Subject: RE: 2023/91835 | 2023/20930 | HDC 7-12NE/8 | location Cliff Hollins Lane, East Bierley, BD12 7ET

I have now reviewed the new car park access proposals associated with the above, in consultation with our S38 team.

Drawing Title:
VEHICLE TRACKING
PUMPING APPLIANCE

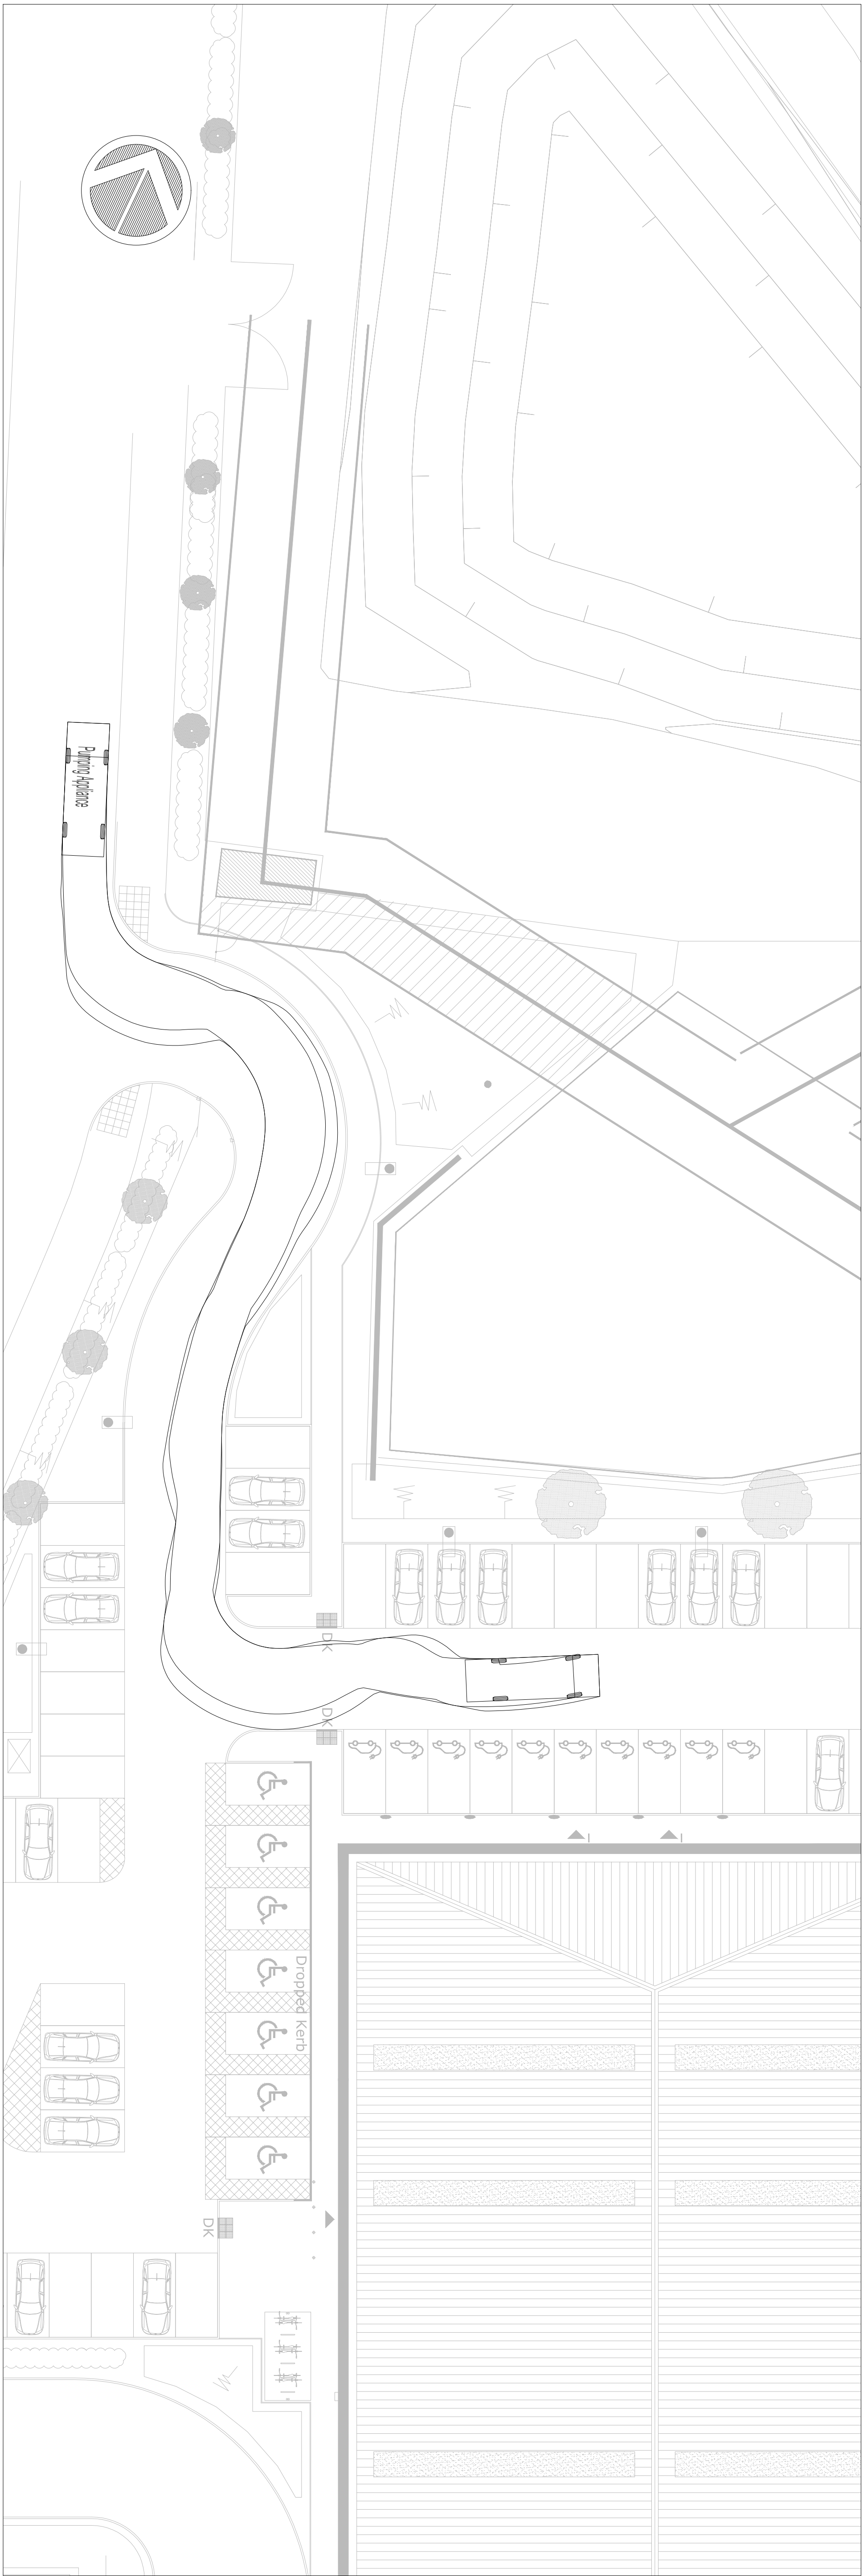
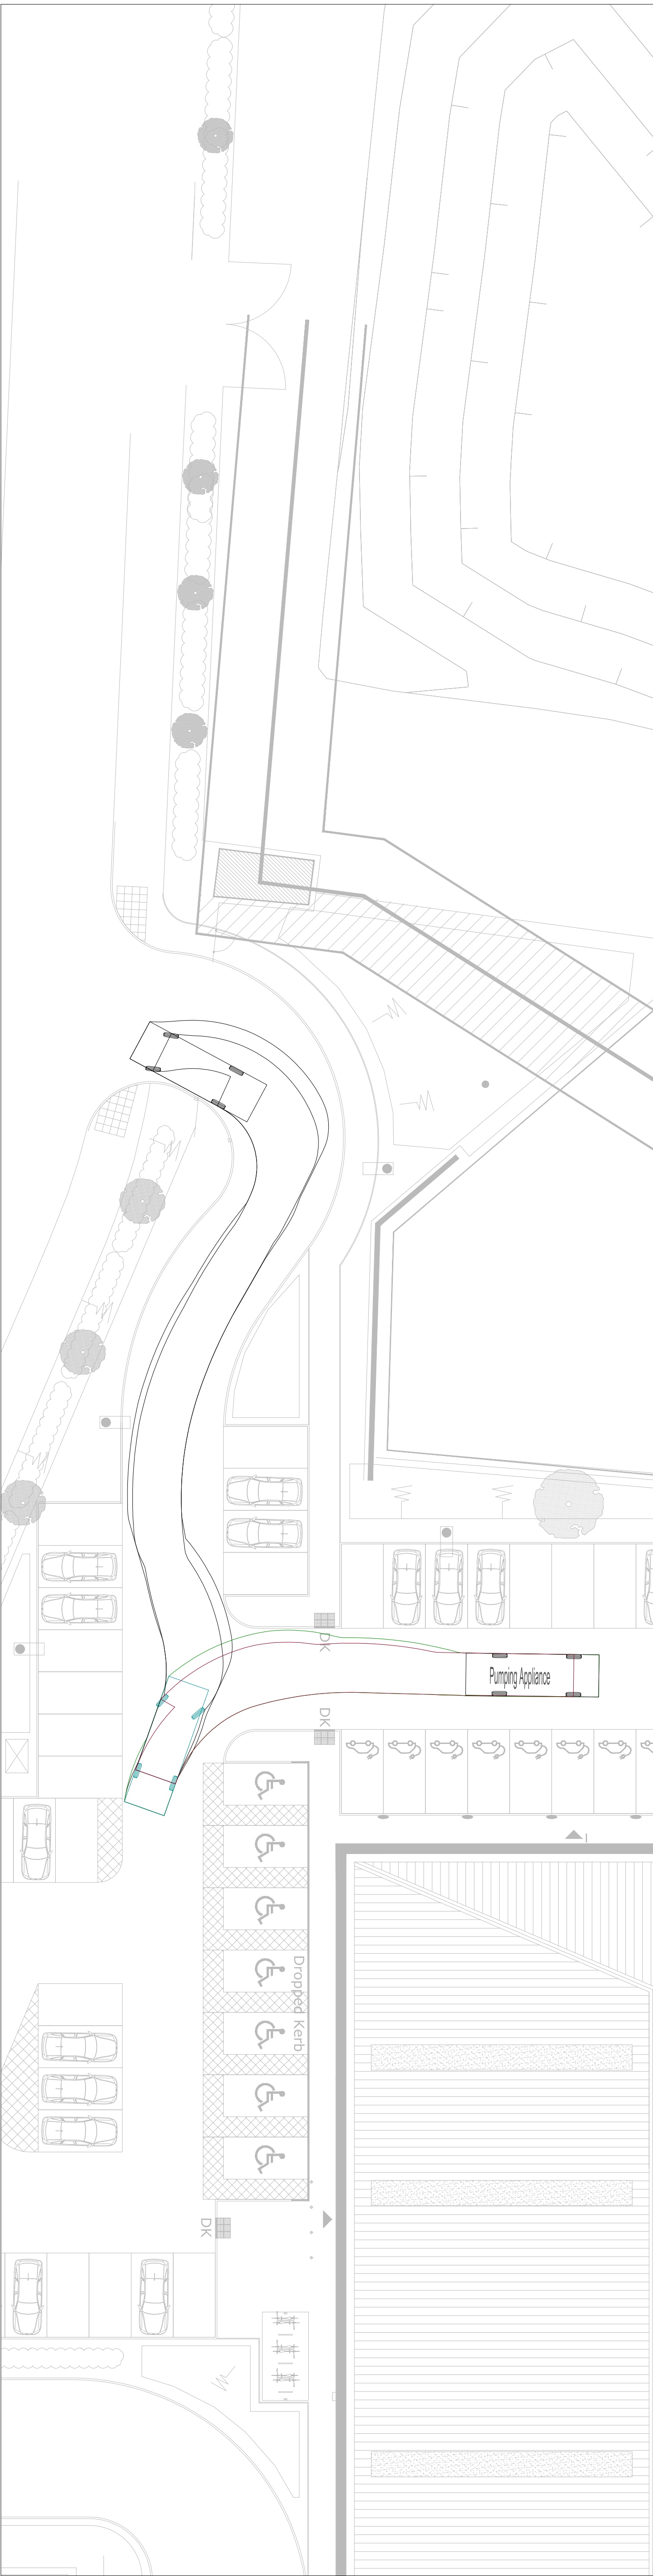
- Confirmation to be provided of any other vehicles that may need to use the site access. Should this include fire tenders (and high reach appliances), which is expected (as this is the only access that will allow access to the north side of the building), then swept path analysis for these vehicles is also required.

Drawing Title:
KERBING LAYOUT

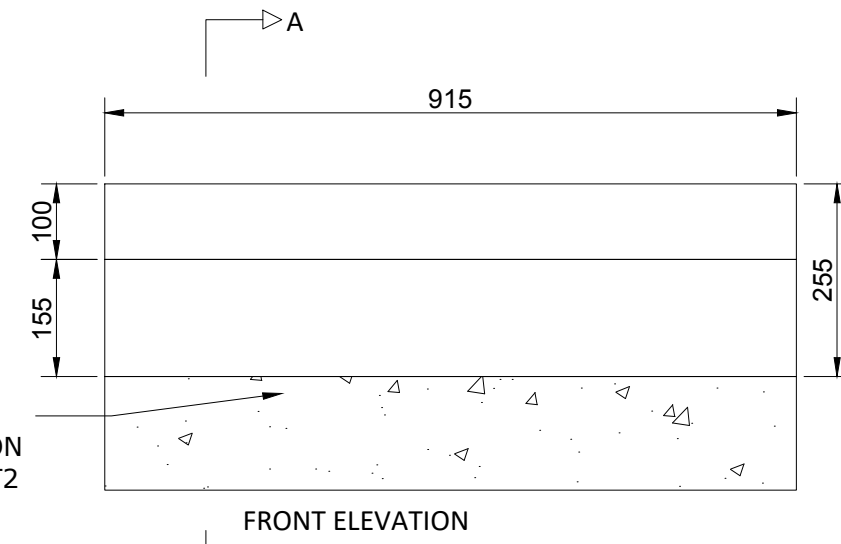
- The junction radii at the site access are different on either side. These should be amended to provide the same size radii on both sides, and should be a minimum of 3m (subject to swept path analysis, which may require a combination of larger radii or a slightly wider access).

- Dropped crossing and tactile paving to be shown at the site access, in accordance with Kirklees Council standard details (<https://www.kirklees.gov.uk/beta/regeneration-and-development/pdf/highways-standard-details.pdf>).

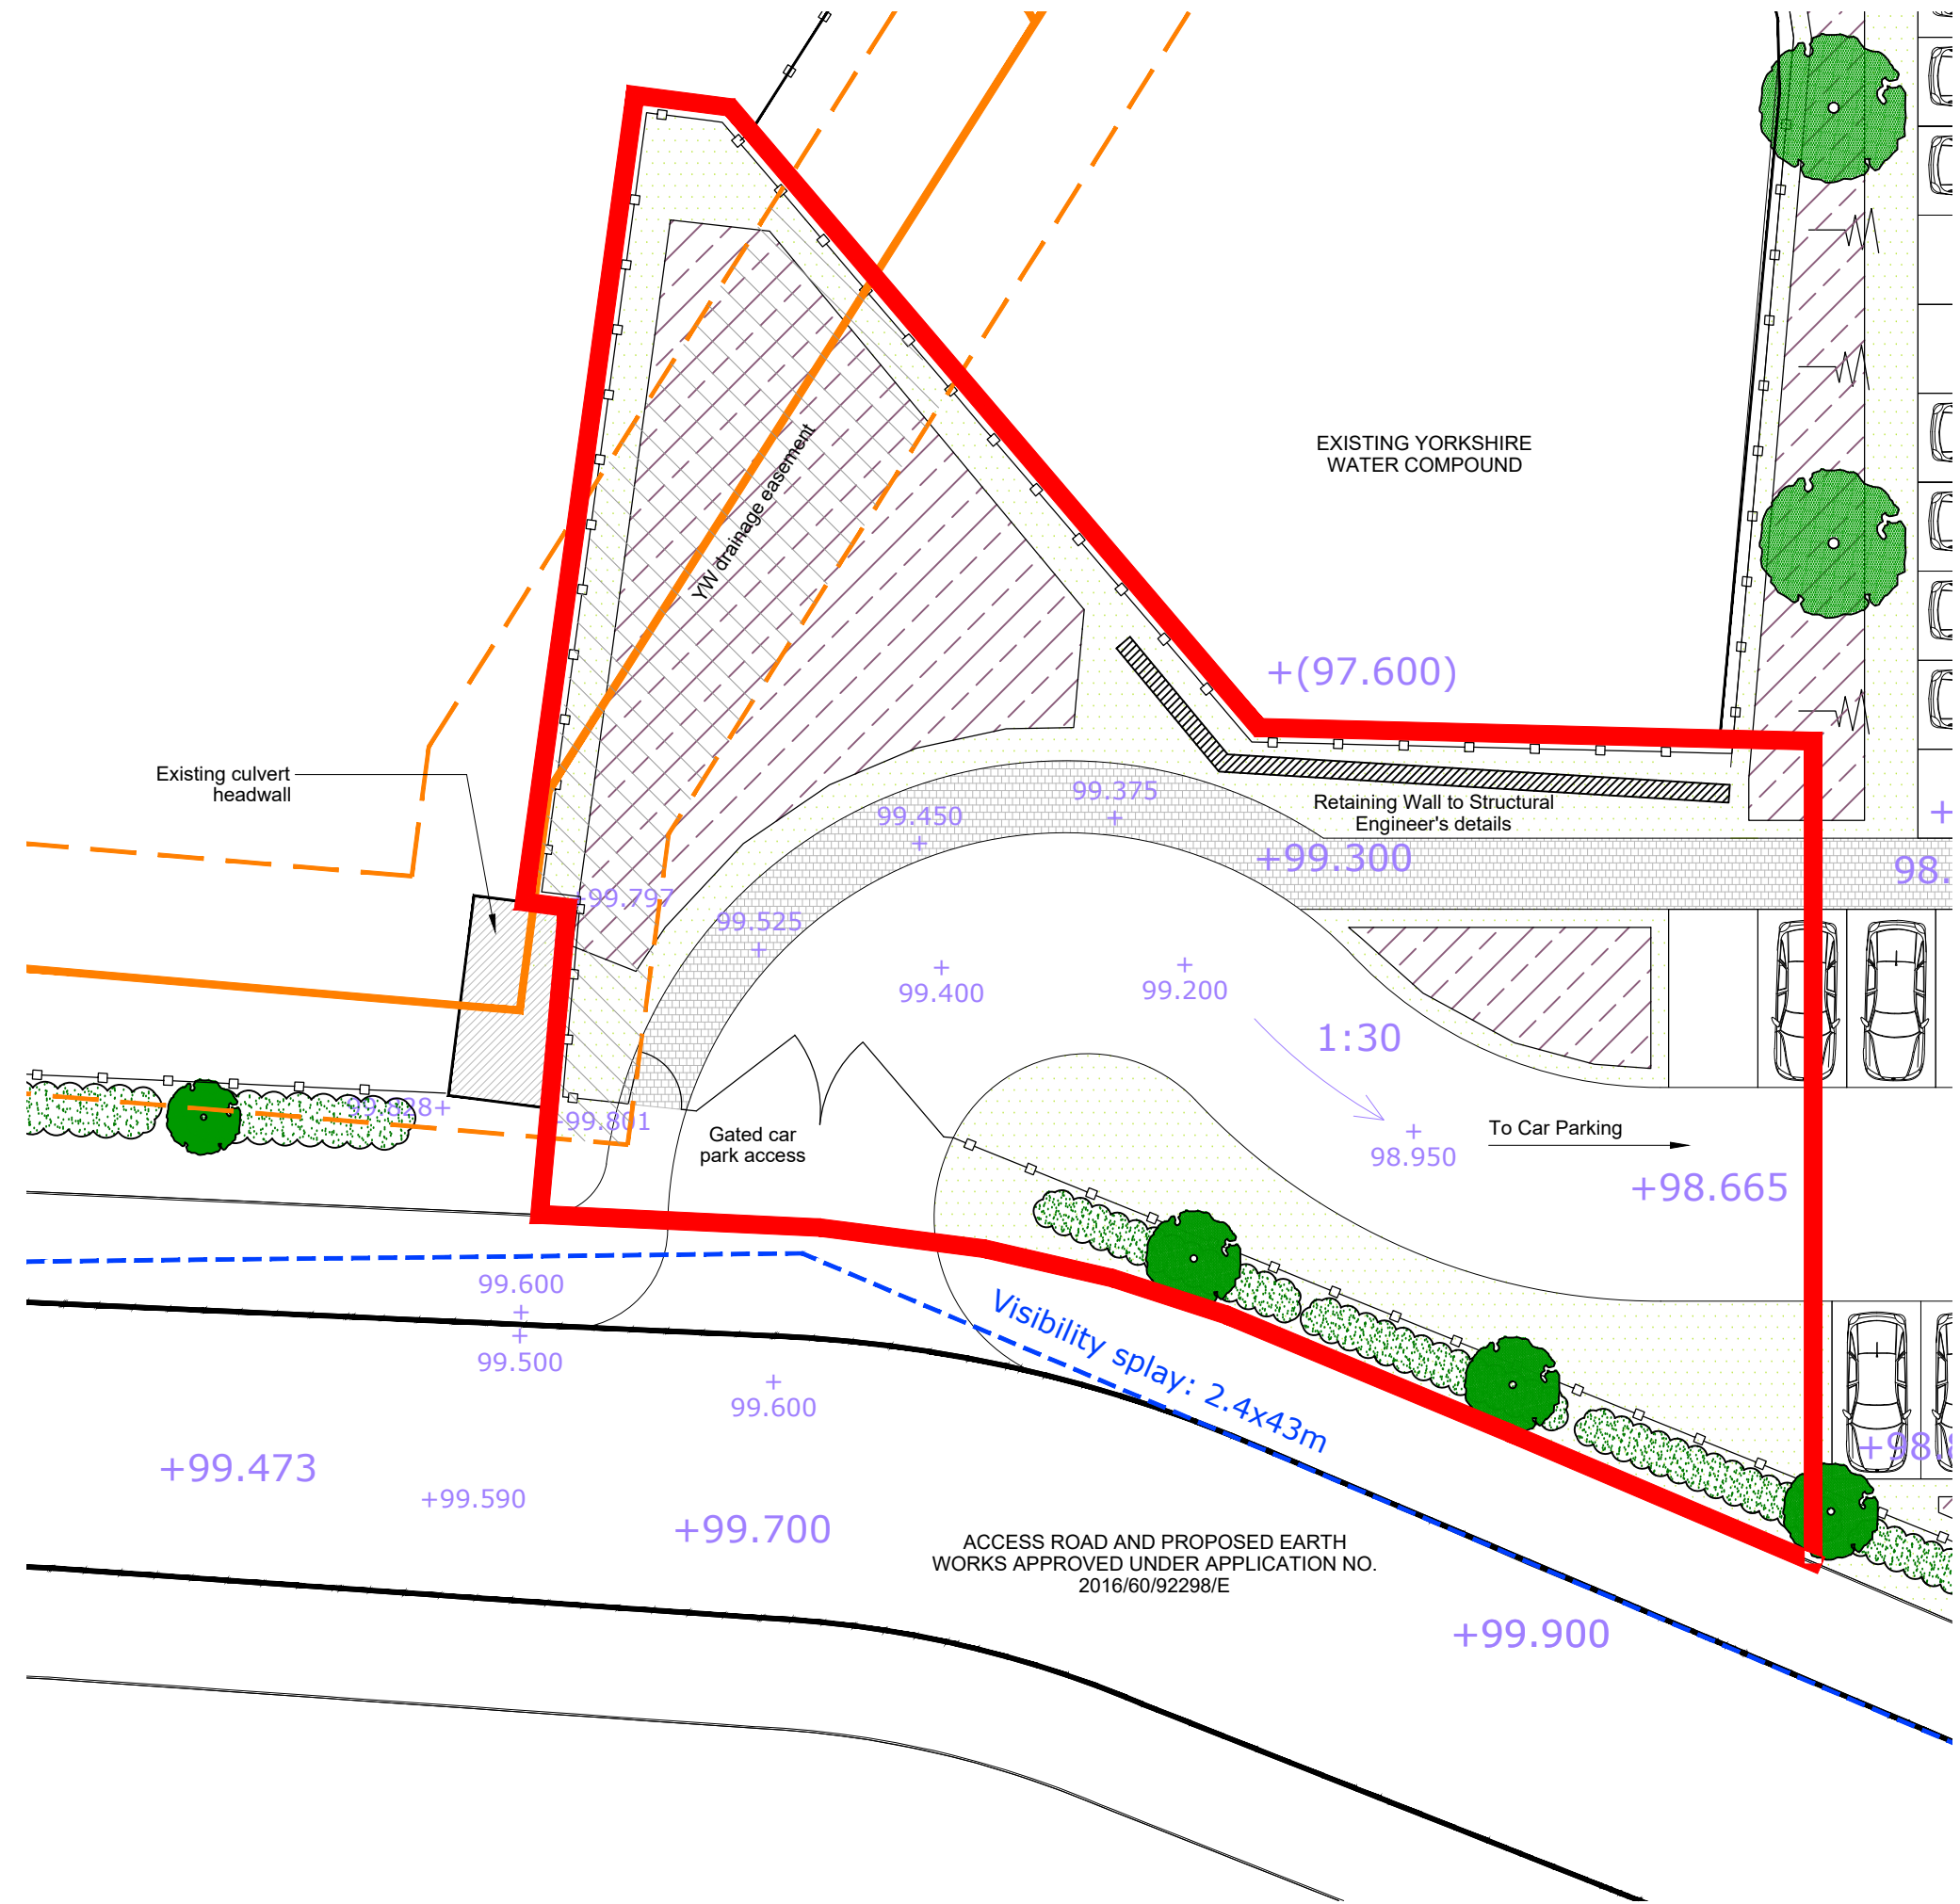
- 2.4x43m visibility splays are proposed at the site access, which are acceptable in principle. However, the splays are not shown fully on the plan. Therefore, a clearer plan is required that demonstrates the full extent of the visibility splays, and confirms that the full width of the major carriageway can be observed. The plan should also show the relationship with the other accesses located on the spine road, to ensure that adequate junction spacing is available, and junction visibility is not compromised by the adjacent accesses.

- Swept Path Analysis is required to demonstrate that large cars can pass at the site access junction and on entry to the car park, with adequate clearance from kerbs and between passing vehicles (min. 0.5m).

- The site access gradients should be confirmed with a long section. The gradient must be in accordance with the Councils Highway Design SPD (<https://www.kirklees.gov.uk/beta/planning-policy/pdf/highway-design-guide-spd.pdf>), including the initial 10m section of the access road including a preferred maximum gradient of 1:40 (or absolute maximum of 1:25).

- Drainage proposals at the site access should be confirmed. These arrangement should ensure that surface water from the spine road does not drain into the site drainage, and visa-versa. It is noted that integrated kerb drainage (e.g. beany blocks) or channel drains should not be used, due to issues with ongoing maintenance.

- Road marking and signage details to be confirmed. This should include give-way markings, warning triangle and signage at the site access, combined cycle/footway signage on either side of the access, and internal speed limit signage and roundels.

- Forward visibility for outbound vehicles on approach to the site access junction appears to be sub-standard and may be blocked by the proposed landscaping and fences. Similarly, visibility for pedestrians/cyclists crossing the site on the combined cycle/footway in the south to north direction will have insufficient visibility to traffic exiting the car park access. Therefore, sufficient forward and pedestrian visibility must be demonstrated, based on the proposed design speed of the site access road (a design speed of 15mph may be appropriate, which would require forward visibility of 17m, and a posted site speed limit of 10mph). Landscaping/fence treatments should then be confirmed, to ensure that unobstructed visibility is achieved at all times when the access is in use.

- The car park gates should be set a minimum of 6m into the site access to allow a large car to wait off the running carriageway of the spine road. In accordance with the above bullet point, the gates/fences and posts will need to be amended to ensure that they do not block visibility.

- Confirmation to be provided regarding the associated changes to the on-site parking provision (all types/modes), and other site layout amendments. At present, it appears that the number of EV charging spaces has been reduced by the revised arrangements, which is a concern. It is also unclear how these wider changes to the site layout are to be agreed, as they are currently outside of the scope of the current redline boundary for this application.
